PROJECT TITLE: TANGLEWOOD SUBDIVISION ZONE ATLAS/DRNG. FILE #: J-101D26  
 DRB #: 96-S44 EPC #: \_\_\_\_\_ WORK ORDER #: 5760.81  
 LEGAL DESCRIPTION: TRACTS 231 & 232, AIRPORT UNIT, TOWN OF ATRISCO GRANT  
 CITY ADDRESS: N/A

RE: ENGINEER CERTIFICATION FOR TANGLEWOOD SUBDIVISION (J10-D26)  
FINANCIAL GUARANTEE RELEASE CERTIFICATION STATEMENT DATED 3/4/98

RE: DRAINAGE PLAN FOR TANGLEWOOD SUBDIVISION (J10-D26) ENGINEER'S  
STAMP DATED 4/29/97

**Re: Tanglewood Subdivision Drainage Report & Grading and Drainage Plan  
Tracts 231 and 232 Airport Unit, Town of Atrisco Grant, Albuquerque, NM  
DRB 96-544**

RECEIVED APR 29 1997 CITY OF ALBUQUERQUE PUBLIC WORKS DEPARTMENT HYDROLOGY SECTION	
TITLE: TANGLEWOOD SUBDIVISION GRADING AND DRAINAGE PLAN	
Design Review Committee	City Engineer Approval
City Project No.	Zone Map No. J-10
Sheet	of

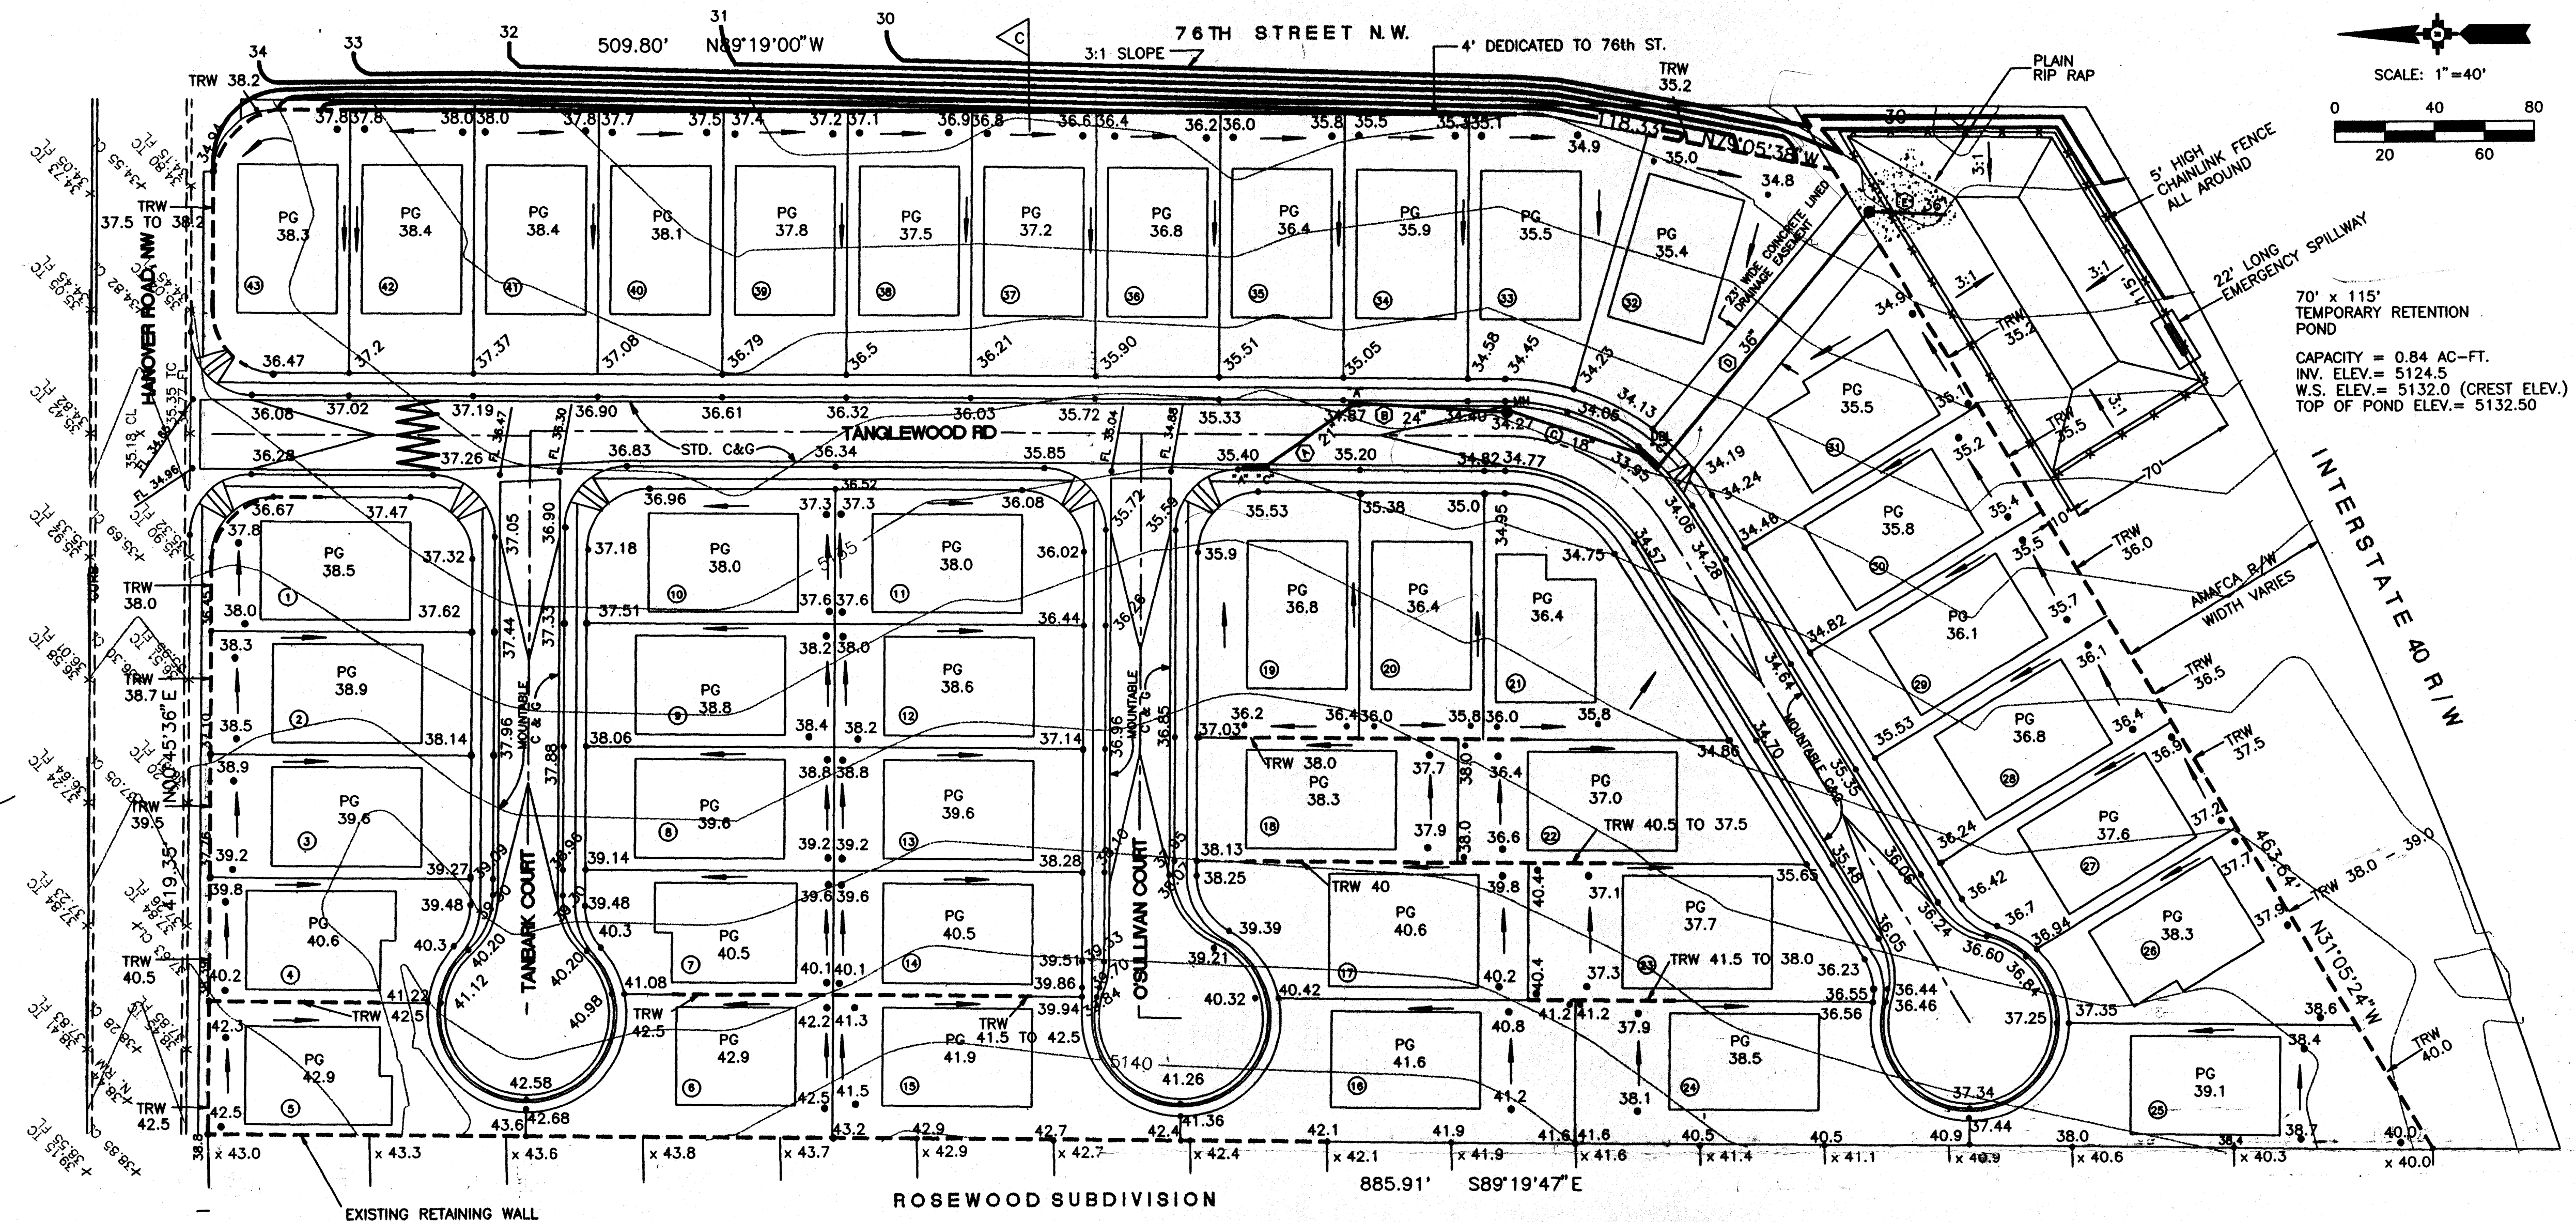
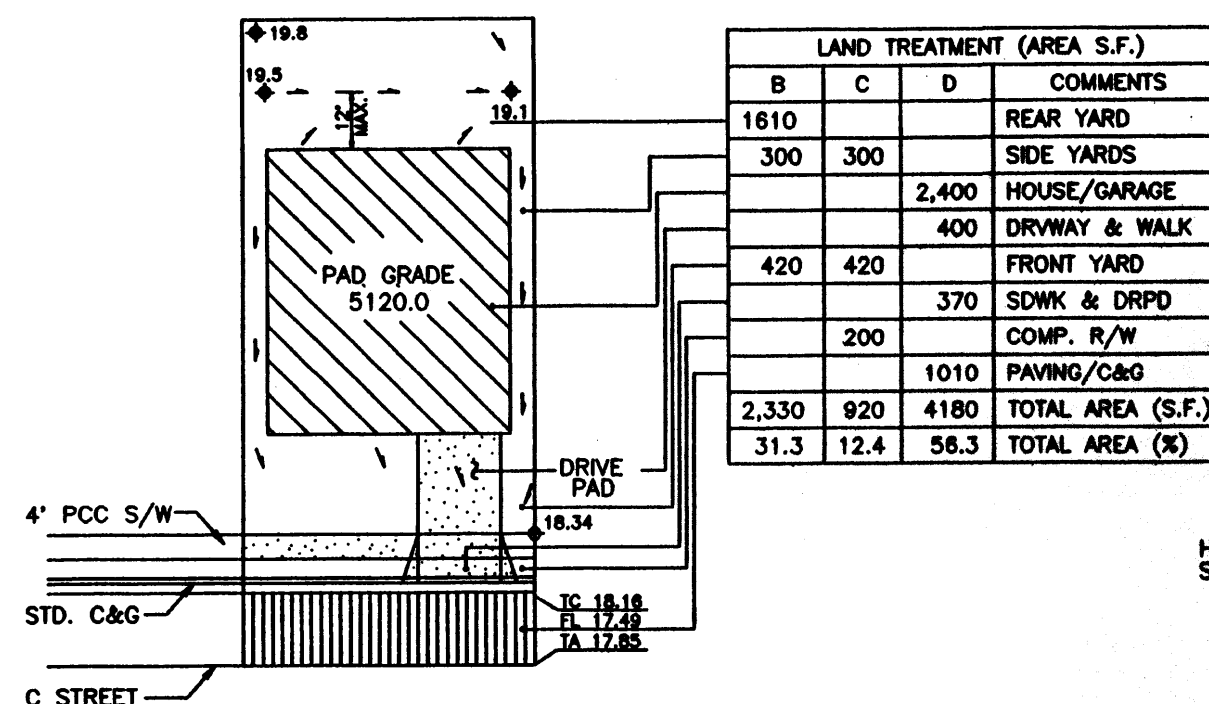
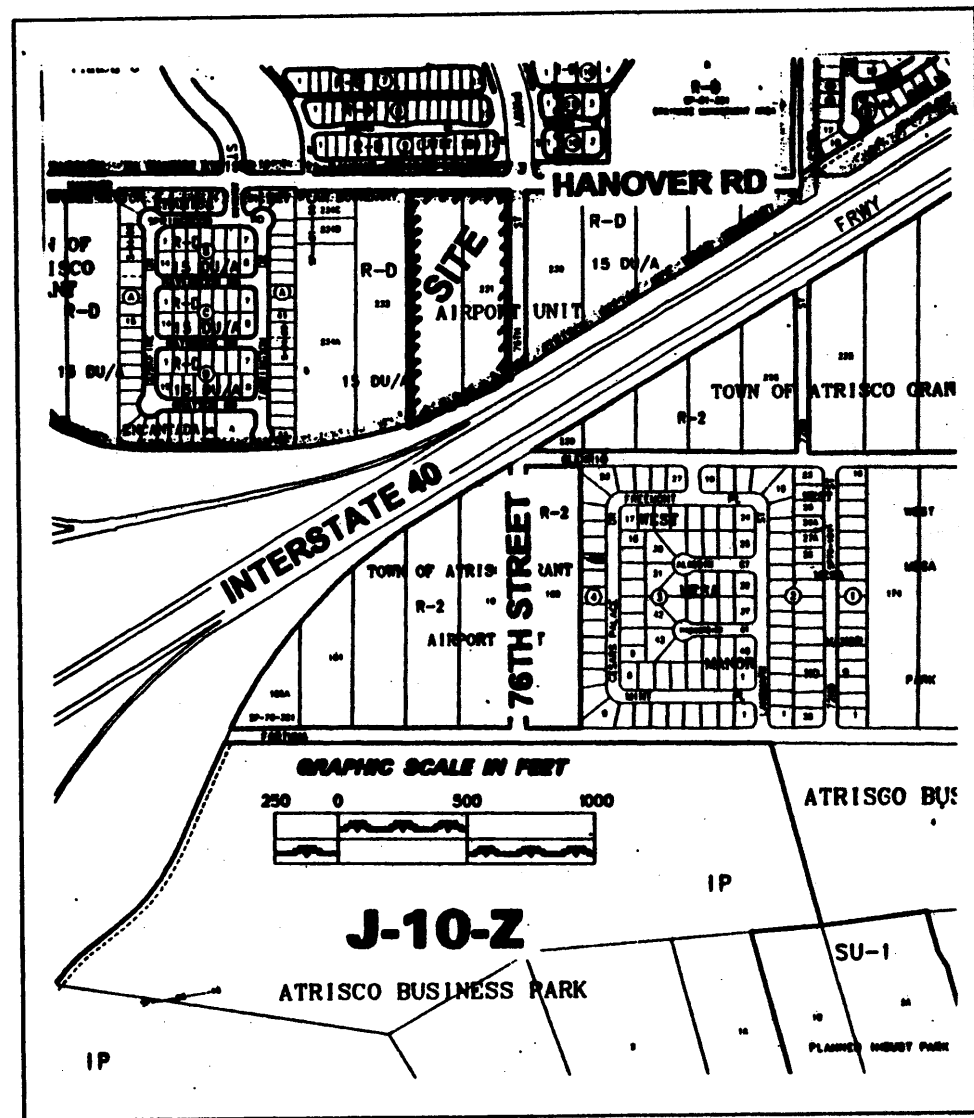
1. Pad elevations will need to be shown to full-mean-level designation.
2. More separation will be required on your proposed "A" inlets on the west side of Tangle-Wood.
3. Copy of the infrastructure list with your resubmittal.

Please find enclosed Revision No. 1 to the above referenced Grading and Drainage Plan. The revision is to address comments in your letter of May 9, 1997 which required that pad elevations be shown to full-mean level designation and that more separation be provided between curb inlets on the west side of Tanglewood. Also, there is a revision to show a 6:1 exterior slope around the proposed retention pond, as requested by AMAFCA. In all other respects, the Grading and Drainage Plan is as previously submitted. Also, as you requested please find enclosed a copy of the approved Infrastructure List.
